Recycling & Recovery

RE: SSD7267 Mod 2 - Response to Submissions

We refer to the email dated 21 November 2018 from the Department of Planning and Environment (DPE) requesting response to the submissions received from various government agencies.

HATCHED AREA DENOTES TEMPORARY PERIMETER ACCESS ROAD (STAGE 1 WORKS)

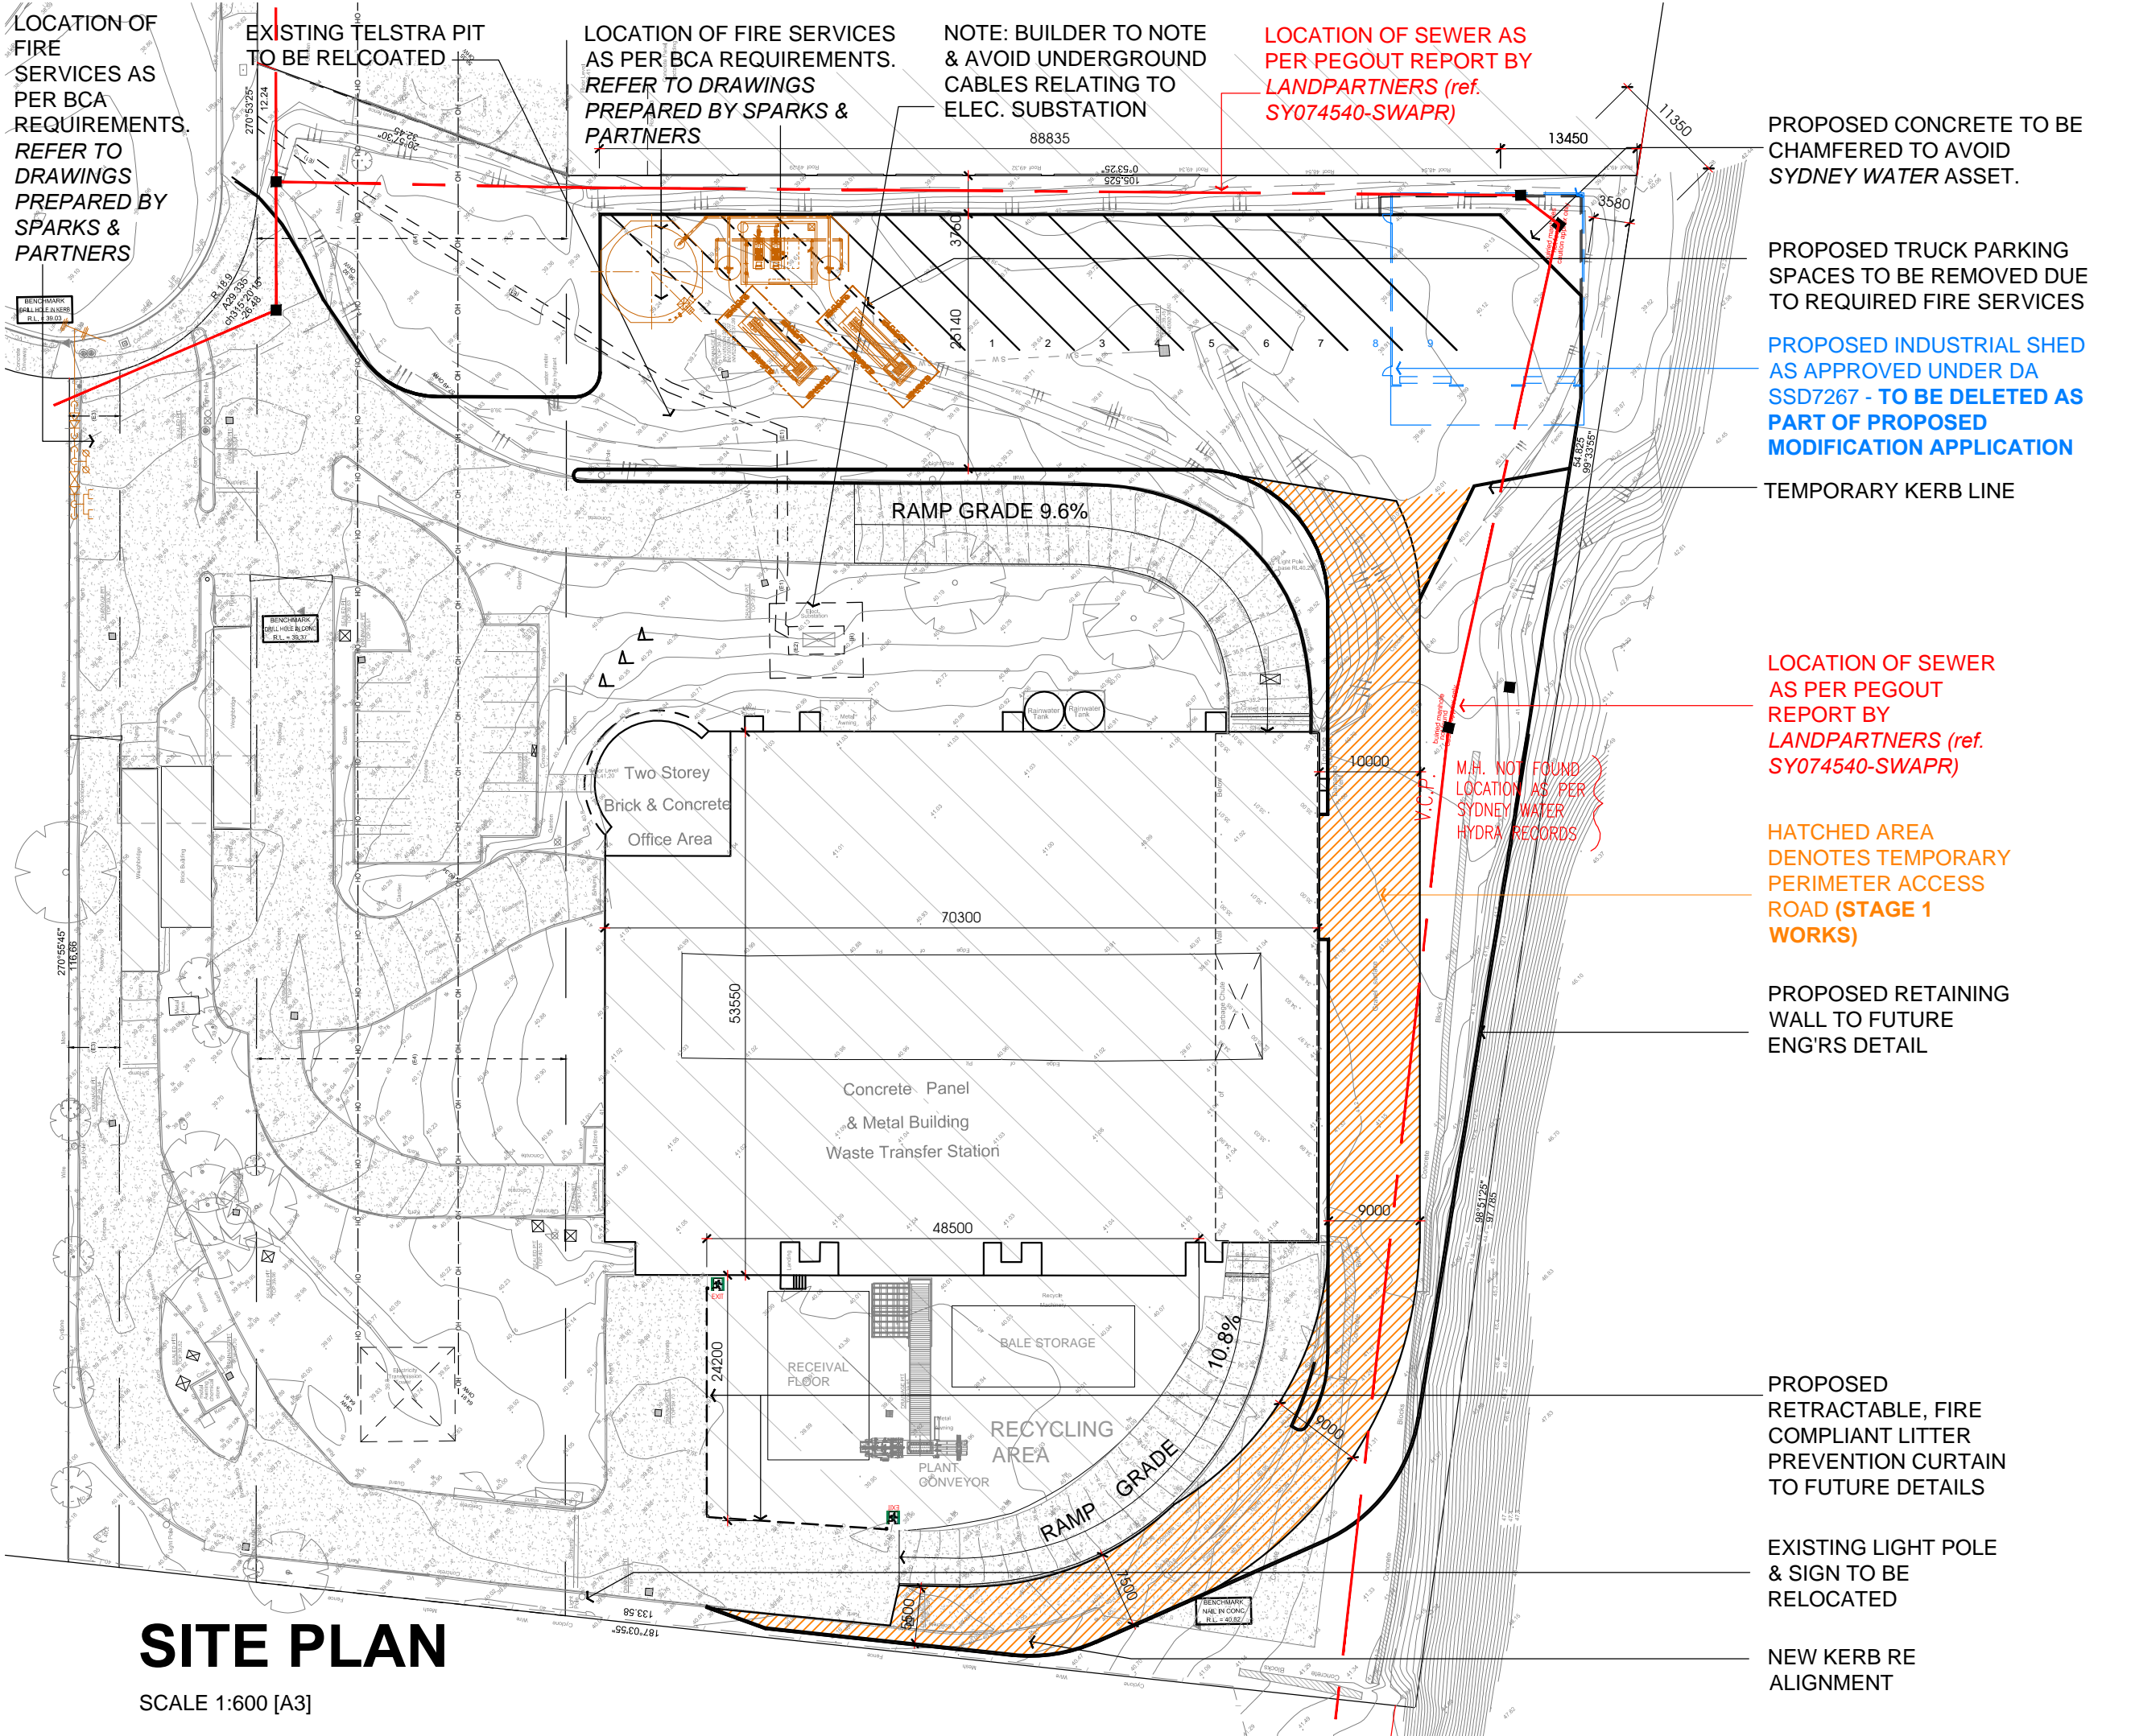
| Council comments | SUEZ responses |
|--|--|
| 2. The submitted plans show that the temporary road is designed in accordance with the NSW FB Policy No 4. The temporary road needs to ensure that the temporary road can accommodate the largest servicing vehicle fully loaded, which may require greater size than the NSW FB Policy No 4. Please refer to Attachment 1. | <p>The temporary road for Stage 1 is proposed as a large isolated building requires a perimeter access road. At Stage 1, this road would only be used by fire service vehicles or other vehicles that would be able to manoeuvre, considering swept path analyses prepared by engineering designers.</p> <p>The road would be expanded as part of Stage 2 works once the neighbour landslip issue is resolved.</p> |

STAGING PLAN

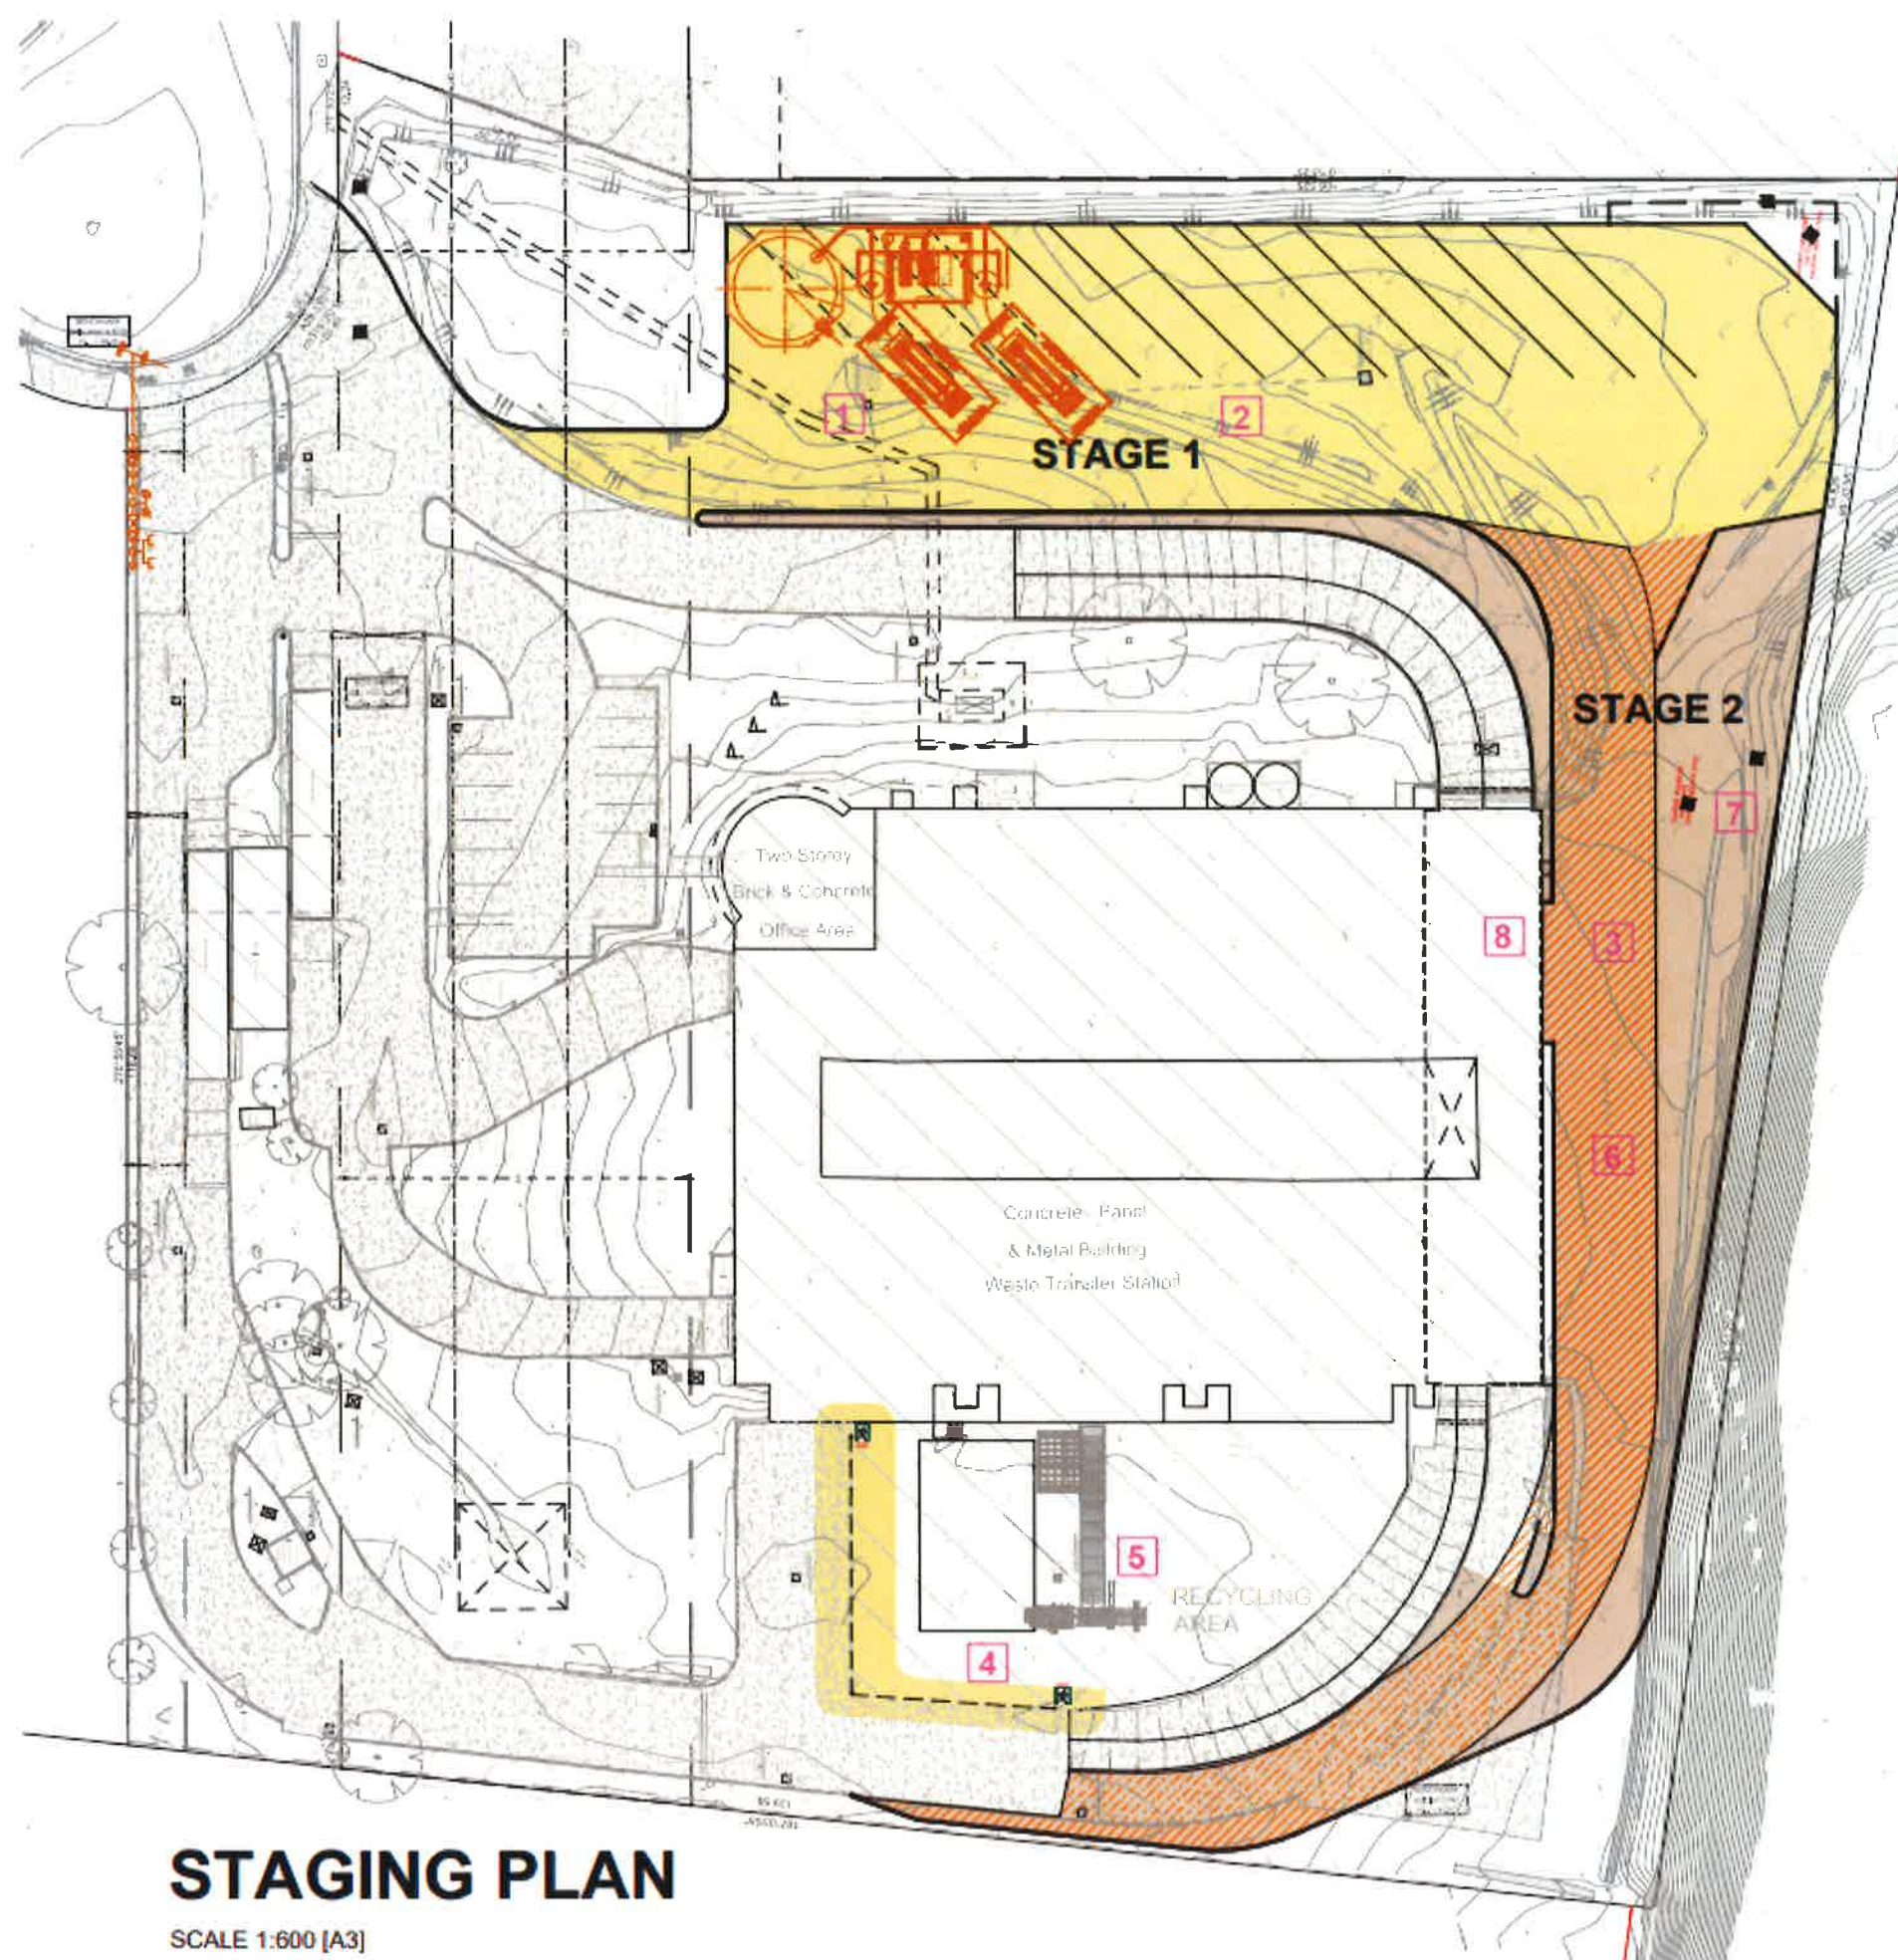
The staging plan (Attachment A Sheet No. CC01) provided in the proposed modification application identifies new plant equipment (5). Please advise

- if the new plant equipment was described and addressed in the EIS? If not, provide additional information on the new plant equipment
- has the noise impacts of the new plant and equipment been addressed?

- if the new plant equipment was described and addressed in the EIS? If not, provide additional information on the new plant equipment
The initial EIS as submitted in April 2016 initially considered a small vehicle drop off area to replace the recycling area located underneath the awning area west of the transfer station building. This proposed small vehicle drop-off area was subsequently removed from the plans after consultation with Transgrid due to its proximity to the Transgrid transmission line structure. This amendment is reflected in SUEZ's Development Application Amendment submitted to DPE on 14 July 2017 and subsequently approved.

This was not considered as there is no additional equipment to what was described in SUEZ's Development Application Amendment submitted to DPE on 14 July 2017. The equipment serves the same function and its location remains in the approved "existing recycling area" per the development layout plans in Appendix A of consent SSD7267. The exact location of the equipment has shifted less than 30 metres and in fact was upgraded from the previous model and would generate less noise than the previous model.
